Recommendation Report for Planning Permission for Works or Extension to a Dwelling

REF NO: EP/7/21/HH

LOCATION: Little Dormers
23 Upper Drive
East Preston
BN16 1QN

PROPOSAL: New bay/porch skirt roof to front elevation & single storey front extension to provide additional garaging.

Drawing Name
Floor Plans and Roof Plan - Proposed

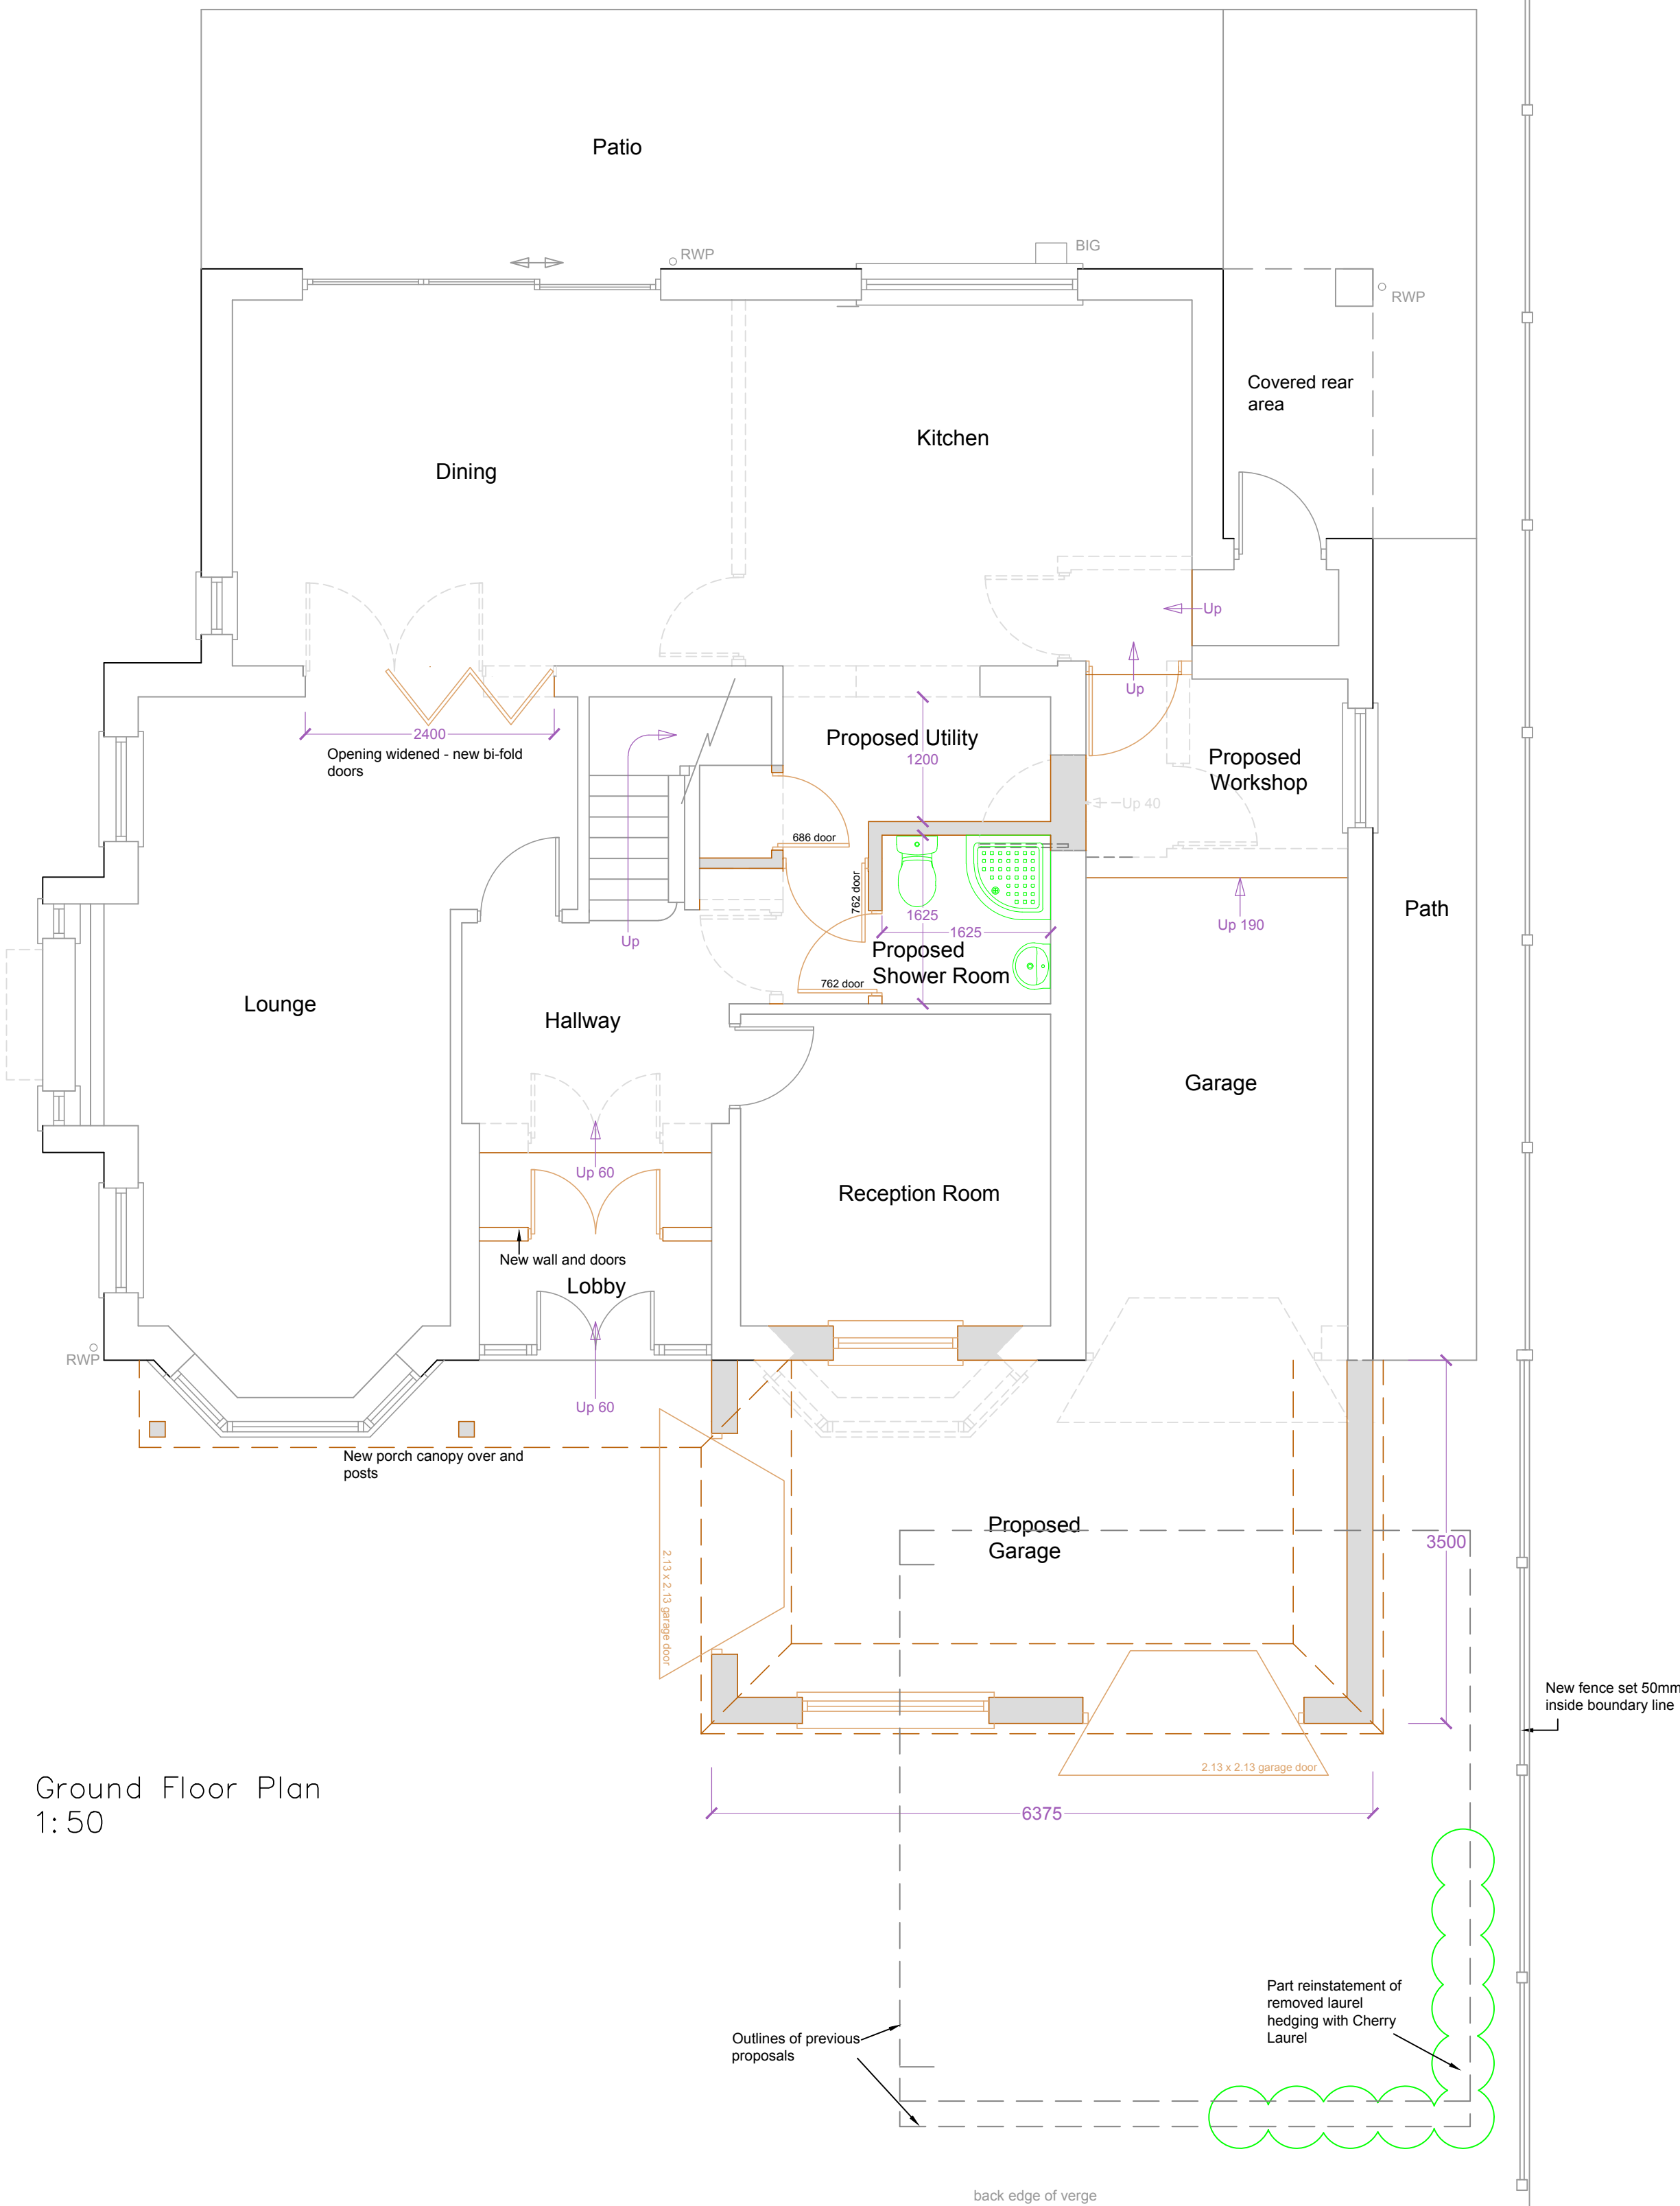
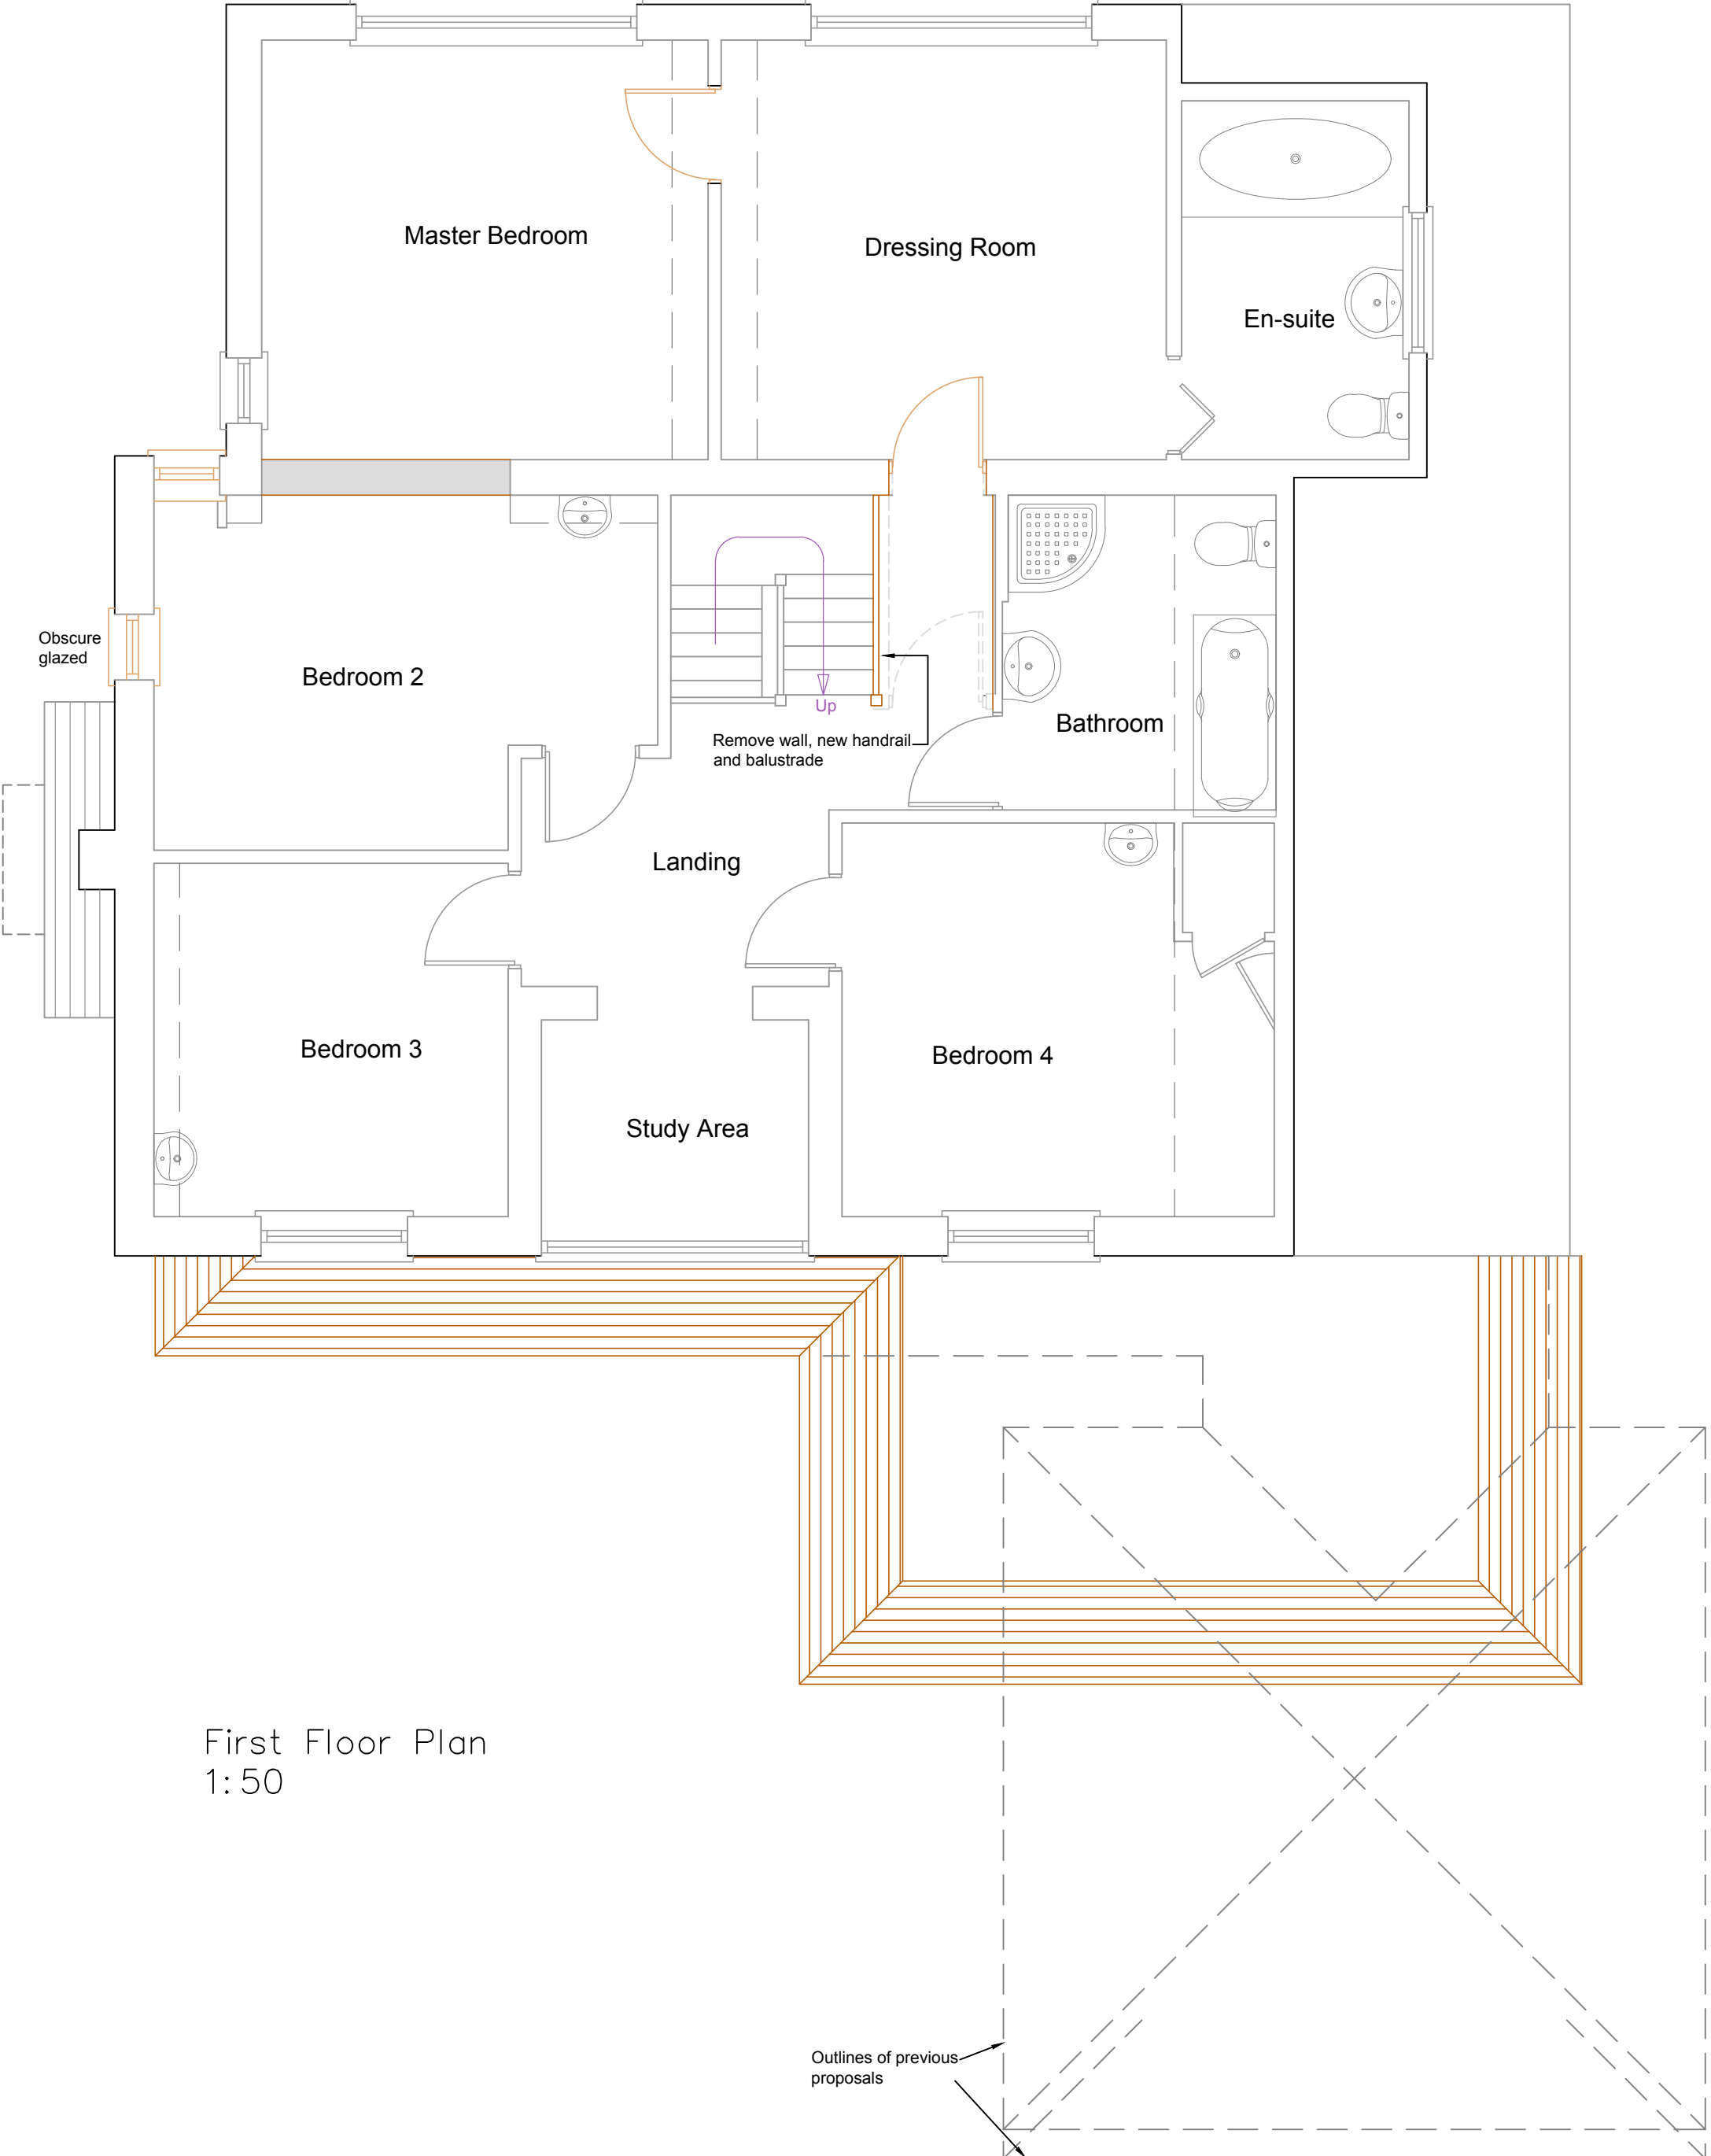
The application seeks to construct a single storey front extension, to be used as a garage and porch. The proposal projects a maximum of 3.54m from the front elevation of the host dwelling, with a width of 12m and a maximum height of 3.2m. The proposed development projects from the front of the host dwelling, and therefore, there will be views of the extensions from within the public realms. However, it must be established that the proposal would result in a harmful impact upon the character of the locality in order to prescribe refusal of the application. The proposed extensions is considered to appear subservient to the host dwelling, and is of a design and scale of which allows the extension to appear well integrated with the host dwelling, and well integrated with the host dwelling. Furthermore, the locality is not considered to have any consistent spatial pattern or building line, additionally, the design and style of the dwellings is varied. As such, the area is considered to have a mixed and eclectic character of which the dwelling is considered to contribute towards.

The proposed development is not considered to result in any harmful overbearing or overshadowing impact upon the occupiers of neighbouring dwellings. This is as a result of the scale, and the siting of the proposed development. The proposed extension is not considered to result in any harmful loss of light to the occupiers of the dwelling directly to the North, this is because even when a 45 degree line is taken from the windows on the Eastern elevation of said neighbouring dwelling, the extension does not infringe upon this line.

Drawing Name
Elevations-Proposed

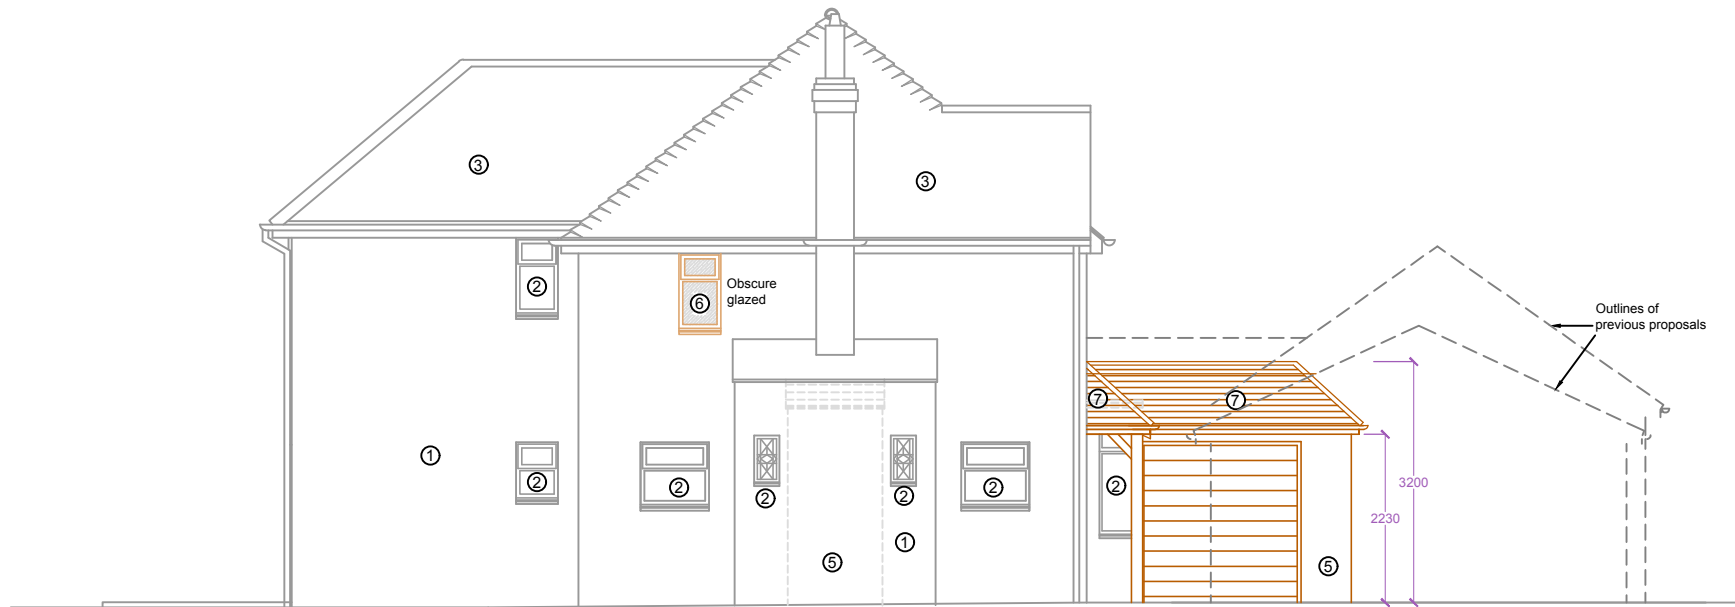
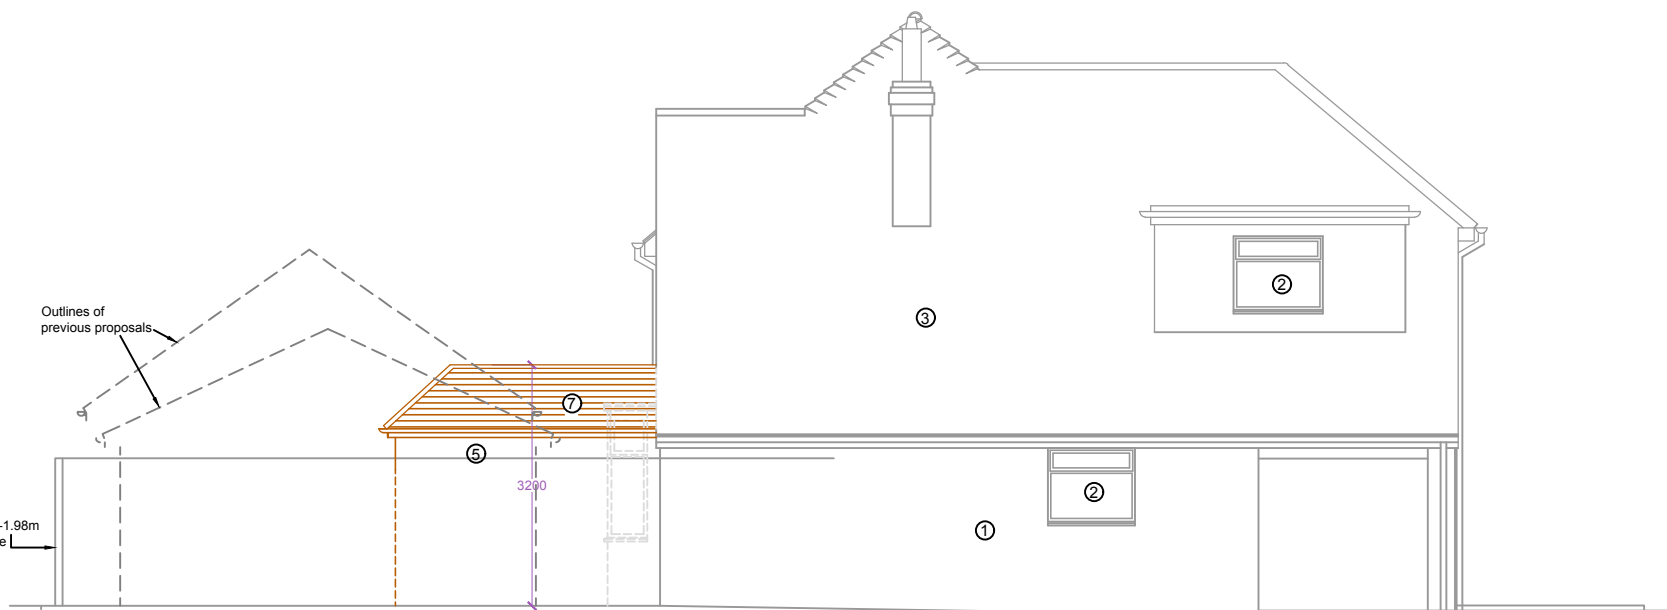
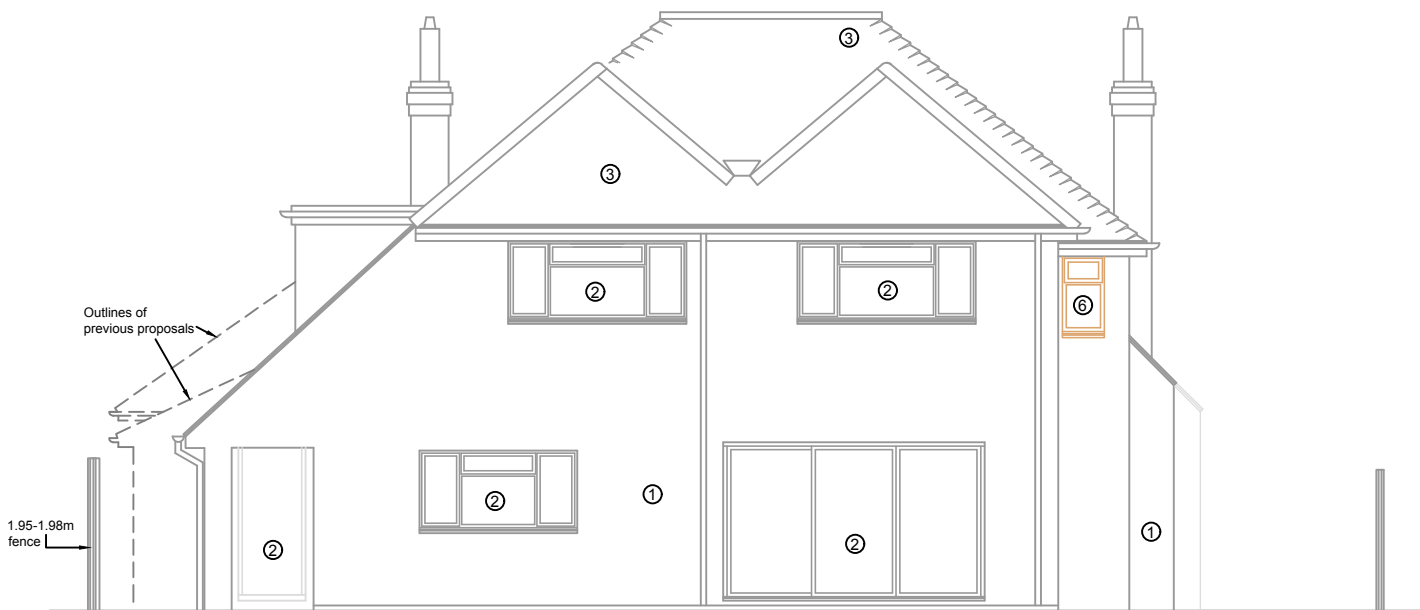
With regards to potential for loss of privacy, the proposed extension is not considered to result in views any different to those available from the application site at current. It is noted that the proposal seeks to create new openings at first floor level, facing towards the South, and the West. To the South, this

windows has potential to result in overlooking and as such, it will be conditioned to ensure that the window remains obscure glazed, and fixed to be non-opening below 1.7m. The window to the West is not considered to result in any harmful loss of privacy, in that views from this window will be within the application site, and any views towards neighbouring dwellings will be oblique only.
